# Norfolk Boreas Offshore Wind Farm Applicant's Comments on Deadline 10 Submissions and Other Submissions

Applicant: Norfolk Boreas Limited  
Document Reference: ExA.ASR.D11.V1  
Deadline 11

Date: May 2020  
Revision: Version 1  
Author: Royal HaskoningDHV

CAWSTON HIGH STREET - INTERVENTION SCHEME  
Scale 1:500

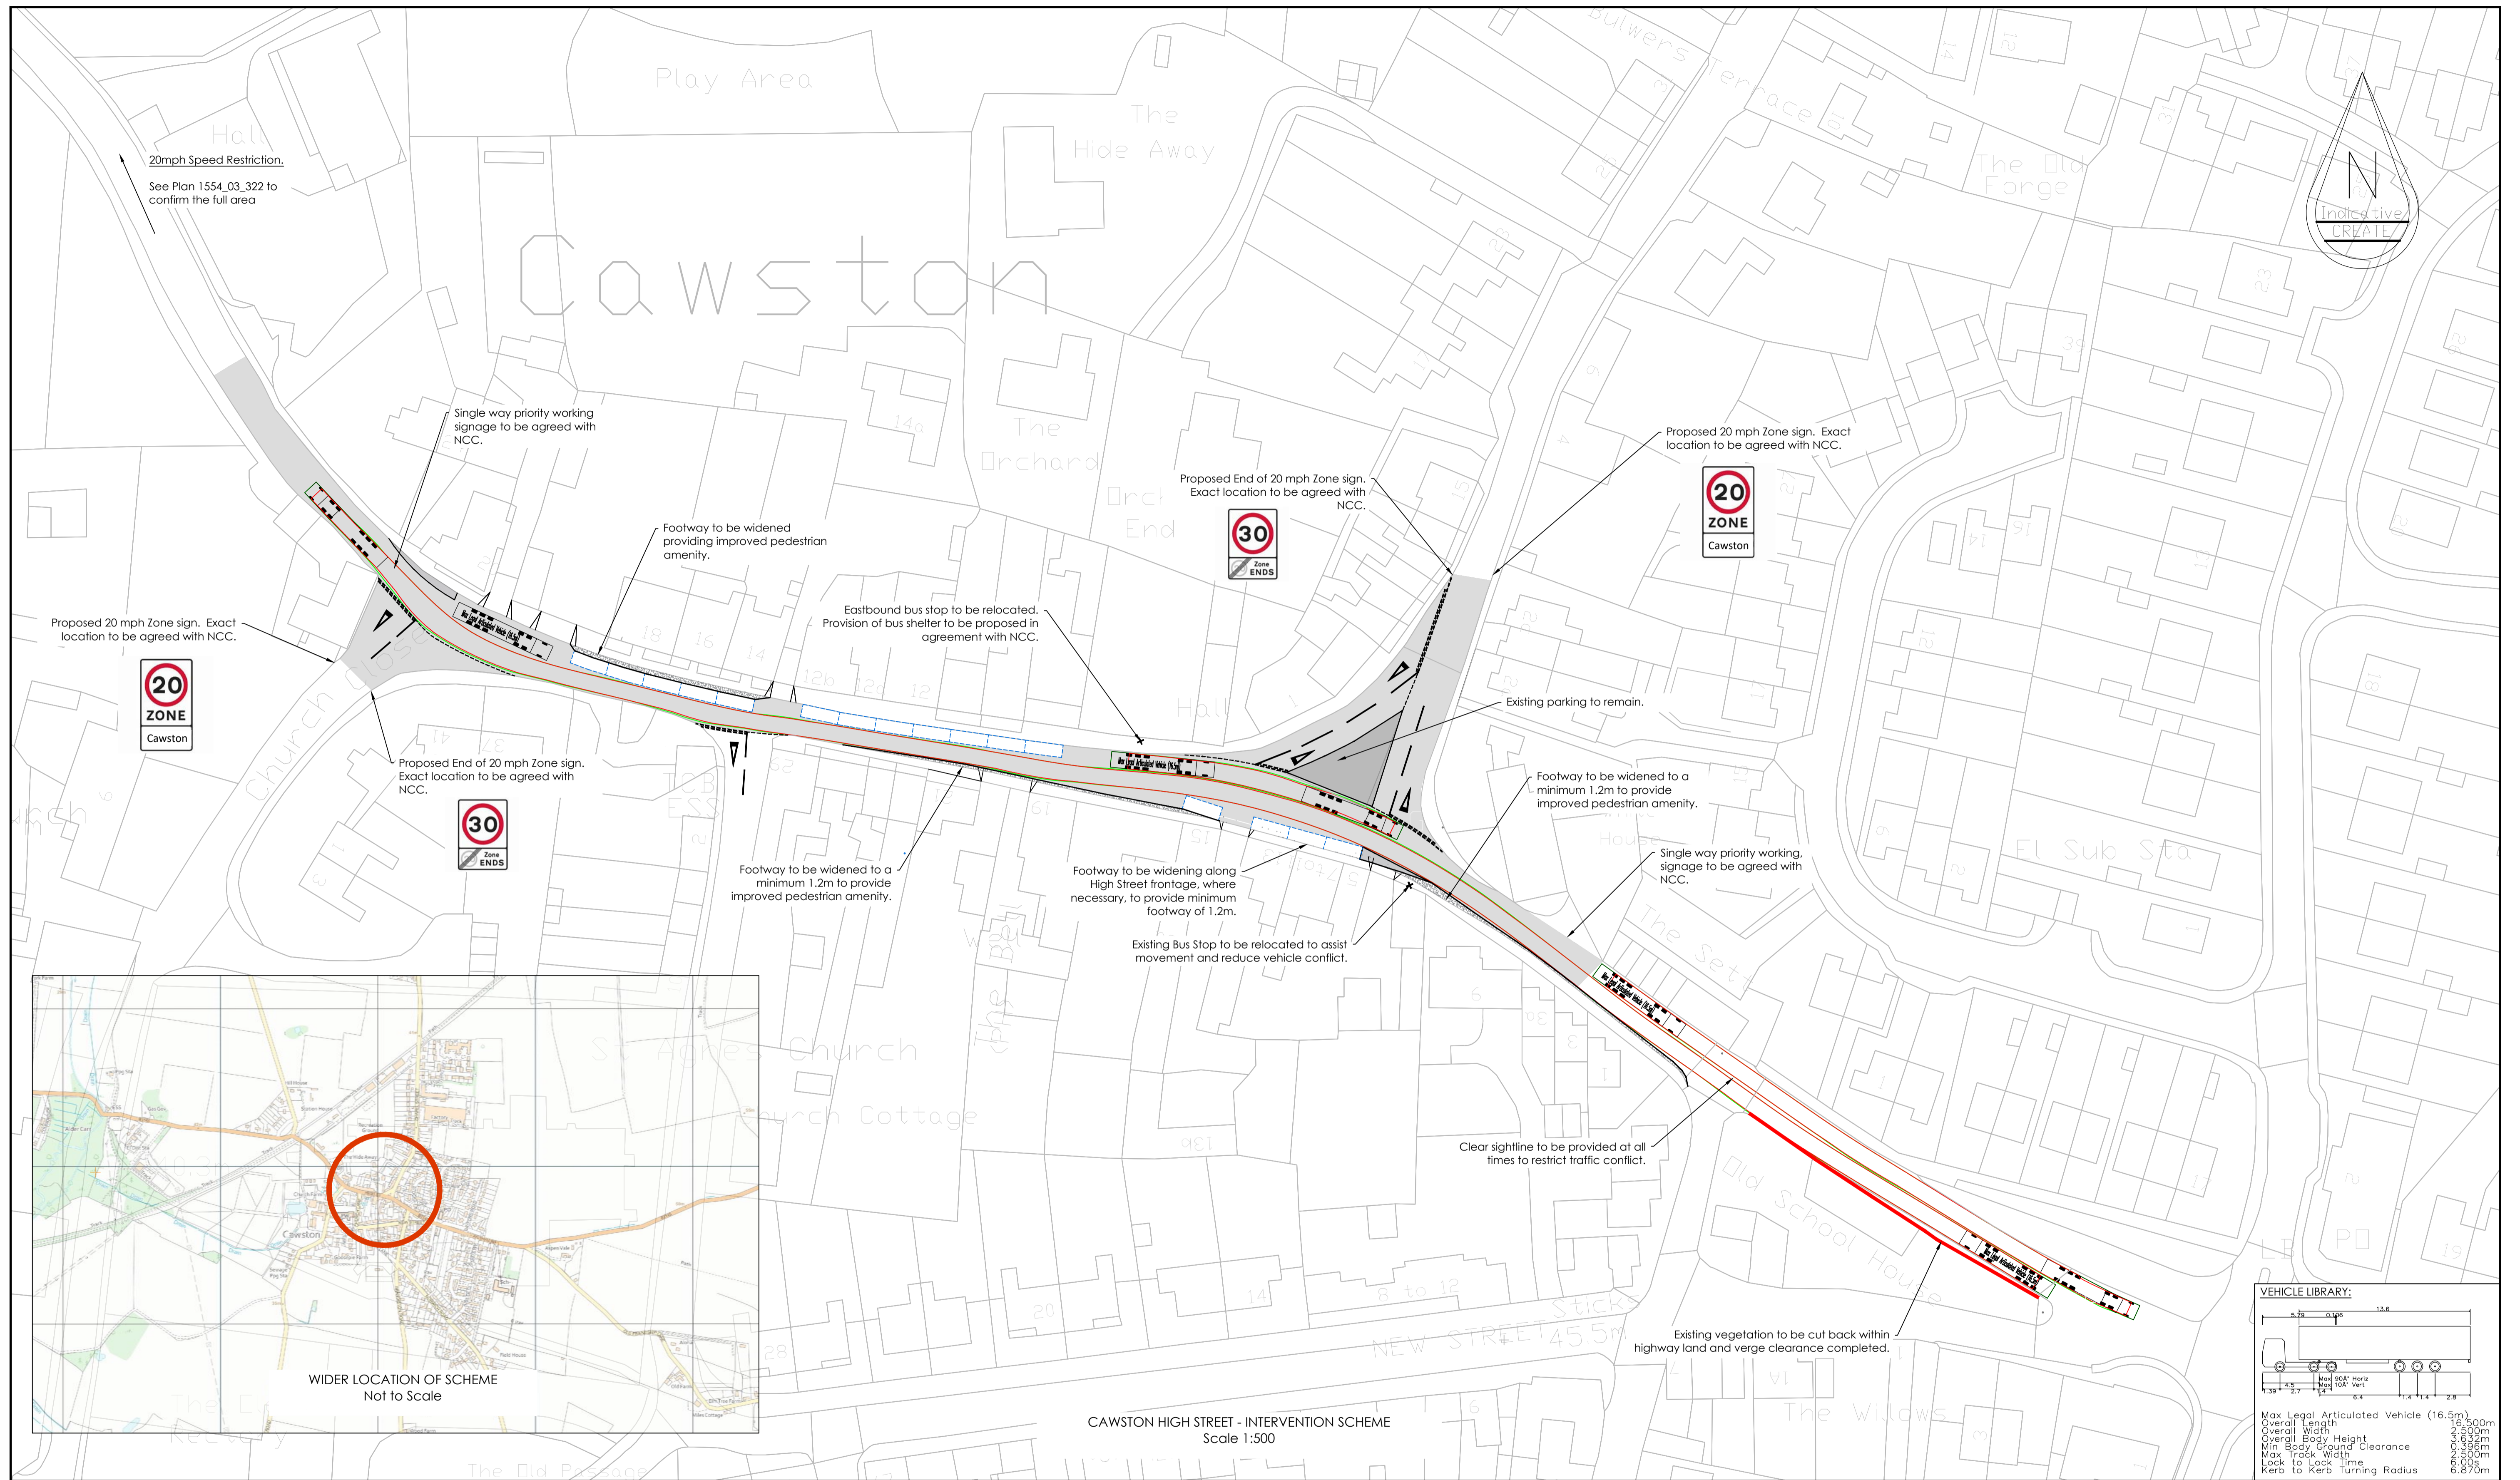
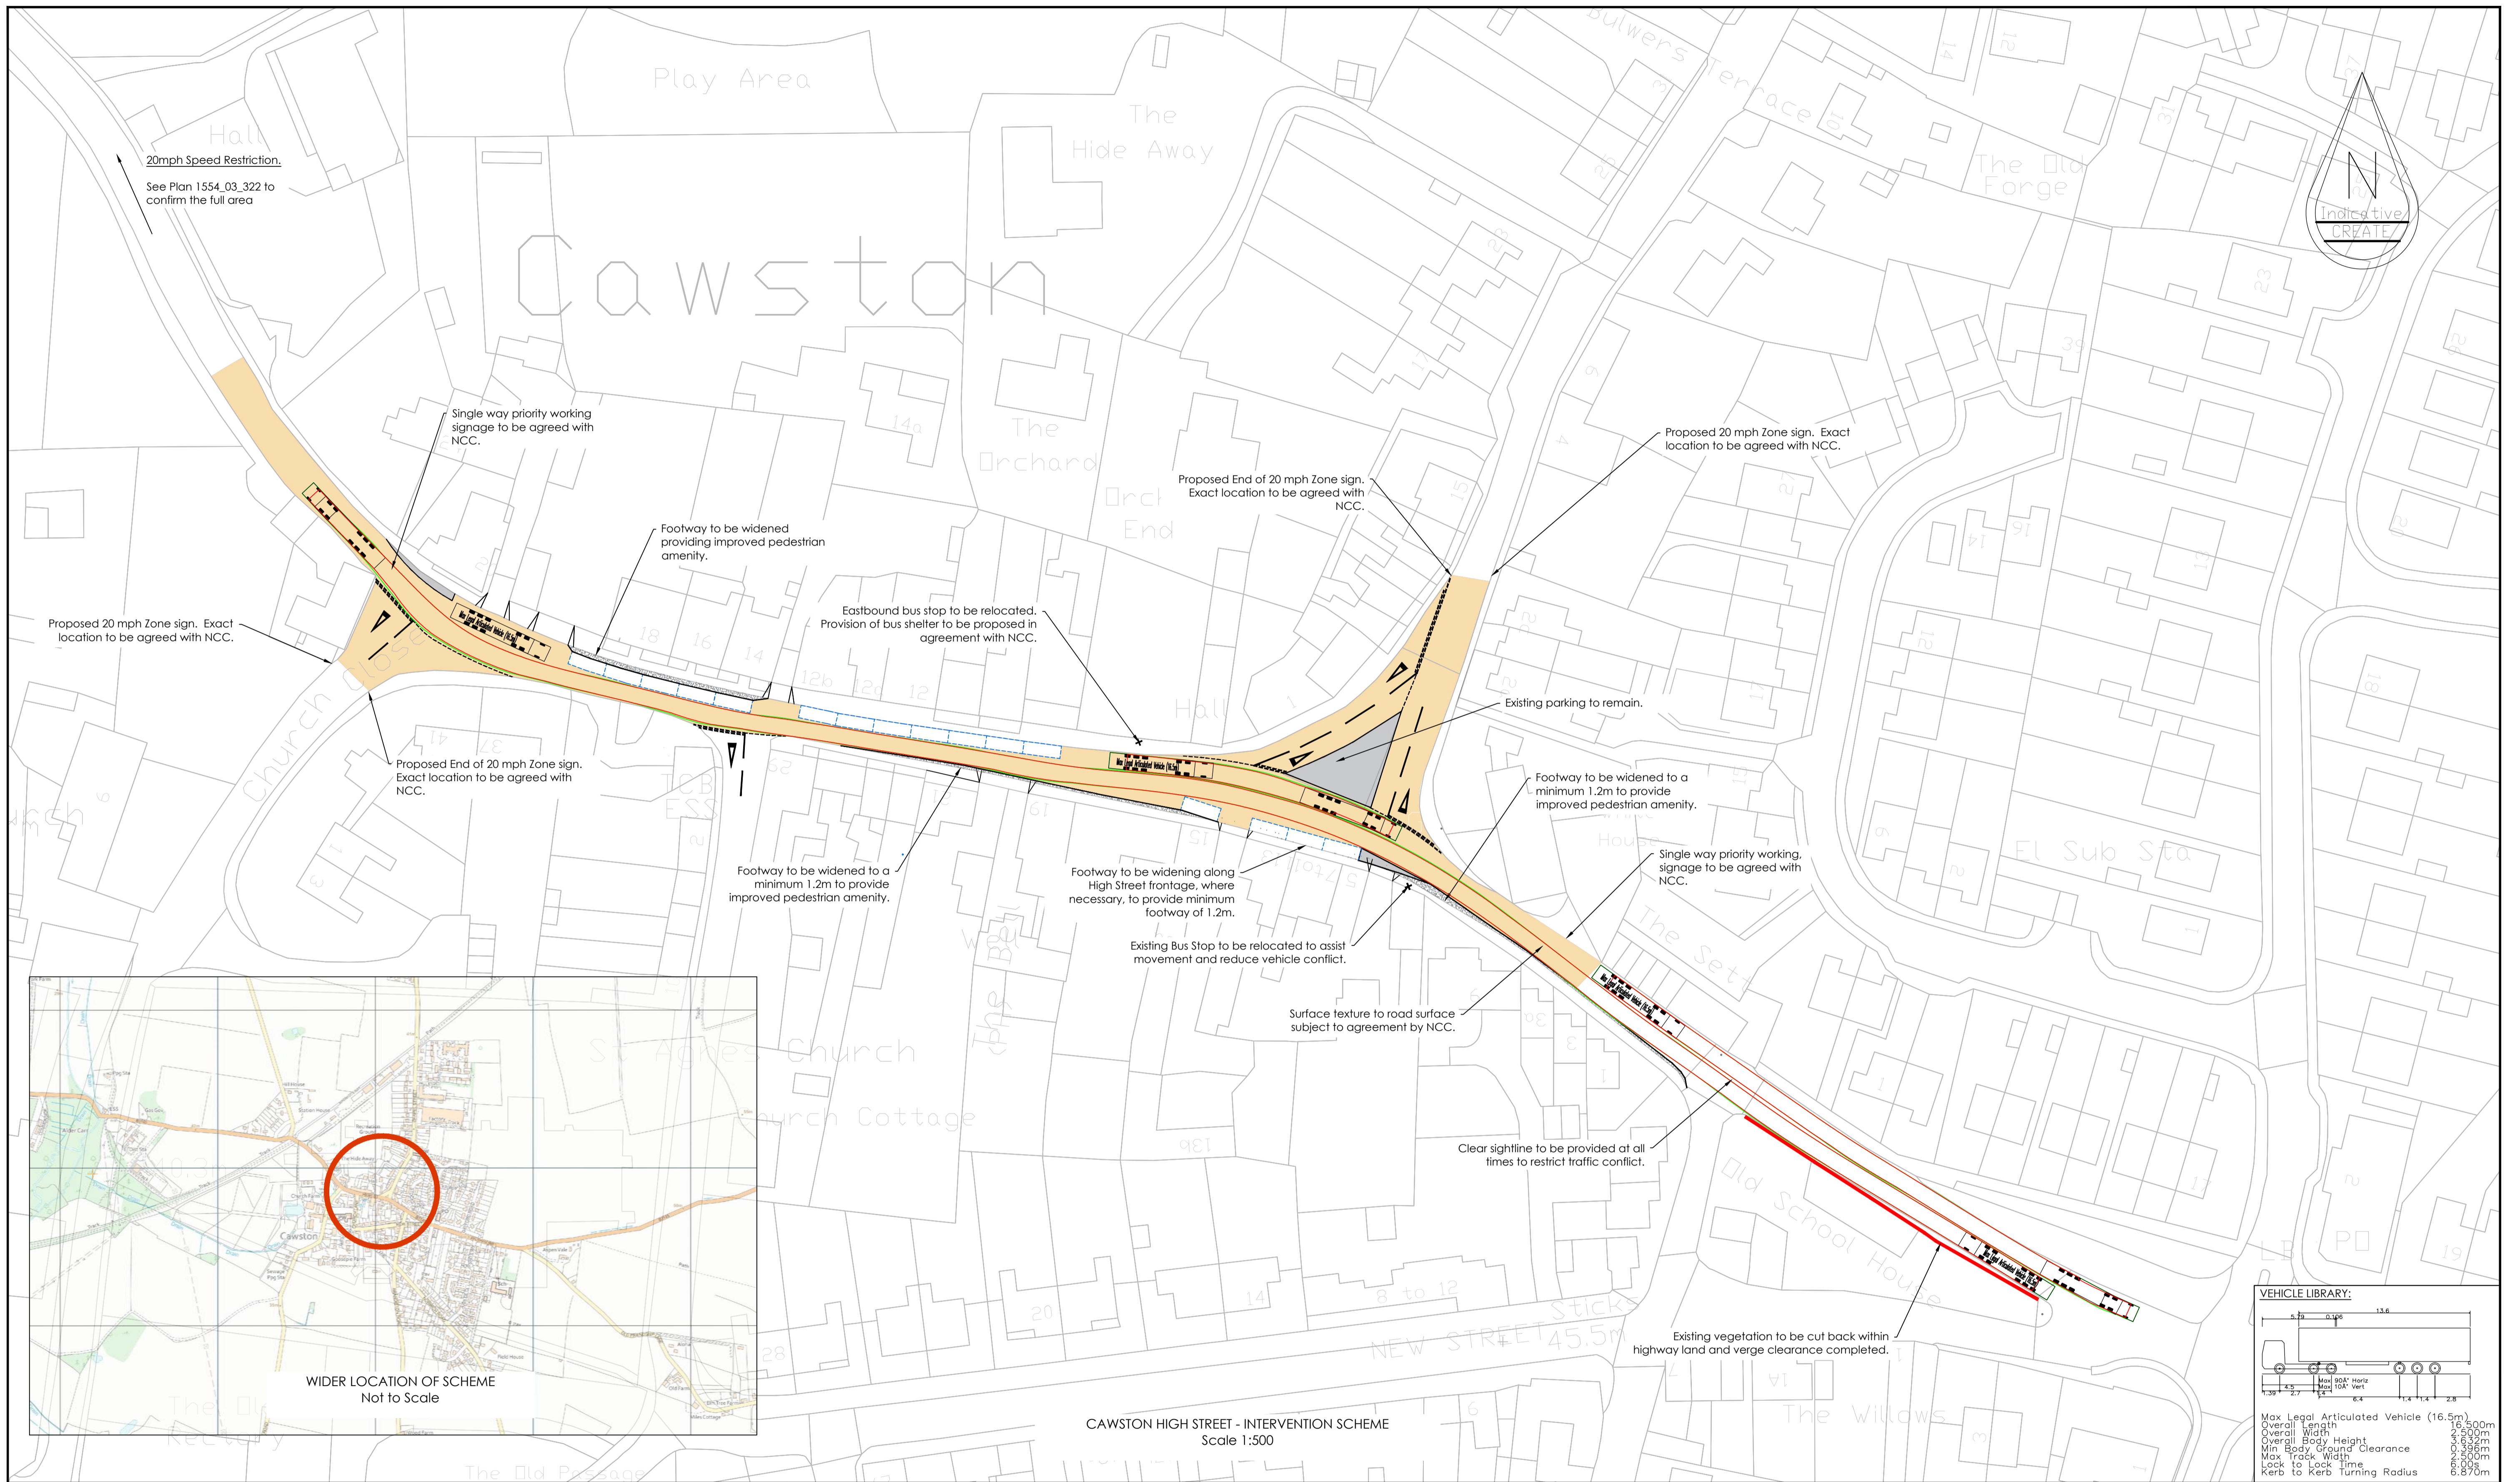
Summary of Submission	Applicant's Comments
<p>The additional width of vehicles from wing mirrors is not shown in the drawings and even in the areas designated for passing the additional width for two sets of wing mirrors and a safe passing distance between them is not evident.</p> <p>Cawston Parish Council views the proposed HIS to be flawed and impractical. For the scheme to have any hope of operating as designed a number of conditions need to be satisfied which include:</p> <ol style="list-style-type: none"> <li>1. The ability of all HGV drivers to be able to see oncoming traffic around corners on the bend at the railway bridge, on the bend by the Old Forge and on the bend close to White House Farm</li> <li>2. A requirement for all HGVs, not only the Applicant's and/or Hornsea 3 project HGVs, to arrive at evenly spaced intervals</li> <li>3. Where two HGVs approach from either East or West they must not have any other road traffic between so they can fit in the proposed system of "passing places". Any train of vehicles longer than the planned "passing space", which is designed for two HGV lengths, will obstruct passing manoeuvres and make gridlock more likely.</li> </ol> <p>Norfolk County Council echoes some of CPC's concerns. The Applicant's Statement of Common Ground with NCC states that:</p> <p>NCC have raised a concern with regard to driver compliance, drivers may potentially fail to yield at pinch points causing traffic to back up, inducing unacceptable delays.</p> <p>In their letter of 27th April (REP8-036) NCC also reiterate their concerns that the HIS could fail</p> <ol style="list-style-type: none"> <li>1. If parking occurs outside the designated parking areas</li> <li>2. Traffic fails to yield at the correct points</li> <li>3. Or if traffic speeds are much higher than 20mph.</li> </ol> <p>Residents of Cawston already see all three of these conditions on a daily basis, and our D6 submission (REP6-042) noted official Government sources showing that 20mph limits</p>	<p><b>Narrow footways</b></p> <p>[REP5-055] Revised Cawston Highway Intervention Scheme Road Safety Audit Decision Log ('RSA log') reports that the Road Safety Audit (RSA) recognises that the likelihood of pedestrian/vehicle conflicts has been reduced by the HIS key design principles of:</p> <ul style="list-style-type: none"> <li>• Providing adequate road space for HGVs to traverse the High Street without the requirement to mount or project over the pavement;</li> <li>• Protecting adequate road space for the HGV routes with the introduction of formal parking controls;</li> <li>• Advance sign warning of 'pinch points'; and</li> <li>• The introduction of a mandatory 20mph limit.</li> </ul> <p>The RSA notes there may be a residual perceived risk to pedestrians and makes the following recommendations:</p> <ul style="list-style-type: none"> <li>• Introduce measures to highlight the presence of pedestrians within the area;</li> <li>• Introduce road markings and 20mph signage at the gateways allowing for maximum impact and awareness;</li> <li>• Provide maximum footway area, by attaching all signs to existing street furniture where possible and introducing any new signposts to the back of the footway, reducing footway clutter.</li> <li>• Review the compliance of drivers following the introduction of the reduced speed limits and introduce further measures if necessary.</li> </ul> <p>The Applicant has accepted all of these recommendations and has incorporated them into the finalised HIS design (detailed in the OTMP [REP10-016]. The Applicant therefore reiterates the conclusion of the RSA log [REP5-055]:</p> <p><i>"Following the evaluation of the key effects that are likely to influence pedestrian risk it is concluded that the likelihood and severity are low and</i></p>

Summary of Submission	Applicant's Comments
	<p>a 20mph speed limit to enable HGV drivers to safely react to the highway environment and 'yield' to oncoming HGVs as required.</p> <p>The HIS design has been informed by a full topographical survey and demonstrates the swept path simulation of the largest UK standard HGV; a 44t articulated tractor and semi-trailer, 2.55m wide trailer, 2.49m cab width and 0.25m wide wing mirrors.</p> <p>In respect of HGV arrival/regulation, the HIS scheme design has been developed to accommodate an even arrival profile for the Project's HGVs (the management of which is secured in the OTMP [REP10-016]) and a random arrival pattern for non-Project HGVs.</p> <p>An intensive monitoring regime and further driver compliance intervention measures were introduced at Deadline 8 in the Outline Traffic Management Plan (V4) [REP8-008] to accommodate the RSA recommendations. In addition, in response to NCC's request for clarification, the text has been refined, as agreed with NCC, and is included in the OTMP (Version 5) submitted at Deadline 10 [REP10-016]. Agreement is confirmed in both the final Statement of Common Ground with Norfolk County Council (Version 3) [REP9-015] and the Applicant's Joint Final Position Statement with Norfolk County Council Highway Intervention Scheme, Cawston (ExA.AS-1.D11.V1) to be submitted at Deadline 11. The range of measures to enable targeted intervention on validation of a driver compliance issue are as follows:</p> <ul style="list-style-type: none"> <li>• Applying the OTMP 'breach' corrective process identified in Section 5.4 and 5.5 to the supply chain;</li> <li>• Further hazard signing;</li> <li>• Introducing mandatory priority 'give-way';</li> <li>• Increased parking enforcement;</li> <li>• A reduction in the cumulative HGV cap (239 HGV movements) by ensuring Norfolk Boreas and Hornsea Project Three traffic demand does not overlap; and</li> <li>• Incrementally reducing the volume of traffic passing through Cawston from 239 HGV movements through targeted intervention</li> </ul>
